From: Technical Sewerage <technical.sewerage@yorkshirewater.co.uk>
Sent: 16 August 2024 13:42
To: Jim Emmerson
Subject: RE: Youth Activity Park, Land of Schwabisch Gmund Way, Barnsley, S71 1AY - Pre-planning Enquiry V535058 [Filed 16 Aug 2024 14:50]

Subject: Youth Activity Park, Land of Schwabisch Gmund Way, Barnsley, S71 1AY - Pre-planning Enquiry V535058

FILE: DRAINAGE GENERAL ARRANGEMENT

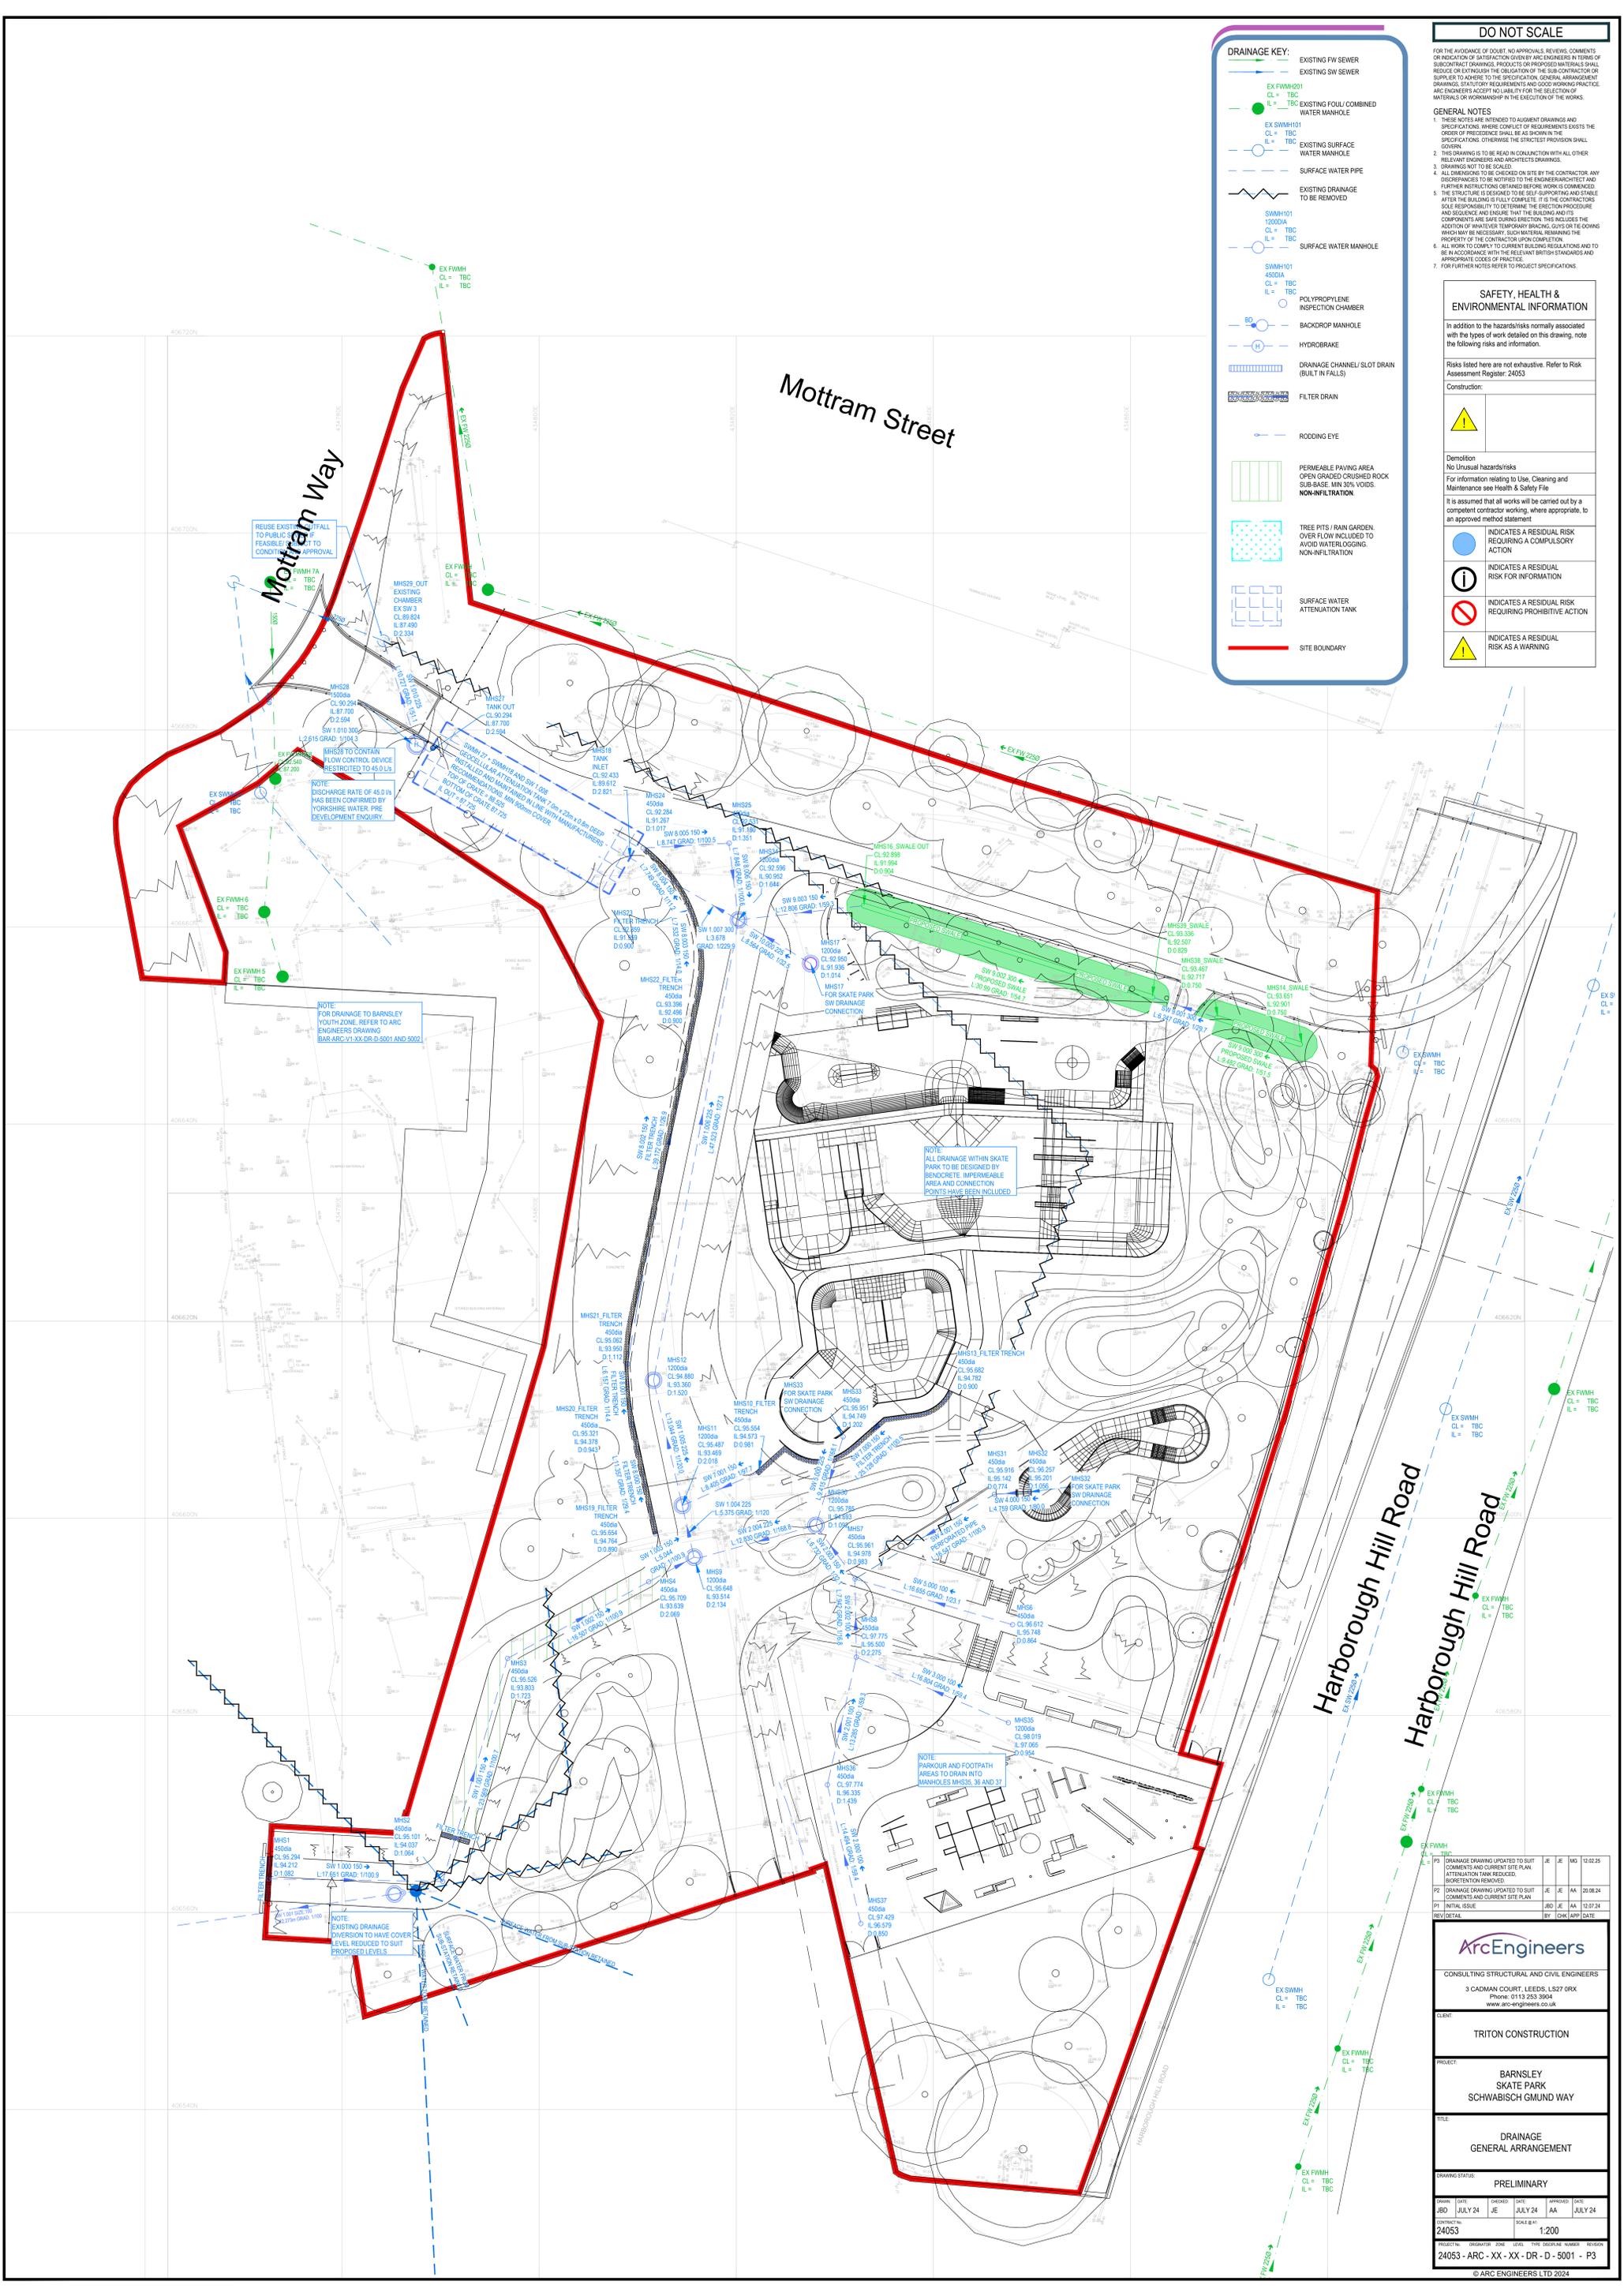
I will need more drainage information in line with the below guidance. While partial drainage has been shown I need to see how the site positively drains at present via existing gullies connecting into this system. There are also areas you have shown shaded green as positively drainage hardstanding that I don't believe are finding their way into the sewer network.

Your drawing BALU-HYD-YAP-XX-DR-C-1000 – Rev P01 and proposal show foul and surface water draining to a private network (possibly combined) and the proposed surface water rate is 99 l/s which is not acceptable without further clarification of how the surface water rate has been calculated and proven to have positively discharged to the public sewer network using the below

guidance. Also if a site is being renovated as per part H3 surface water should always discharge to a surface water network when available over a combined network.

I would accept the 45 l/s maximum surface water discharge via the onsite private dedicated surface water drainage that in turn drains to the 525 mm diameter public sewer in Eldon Street North.
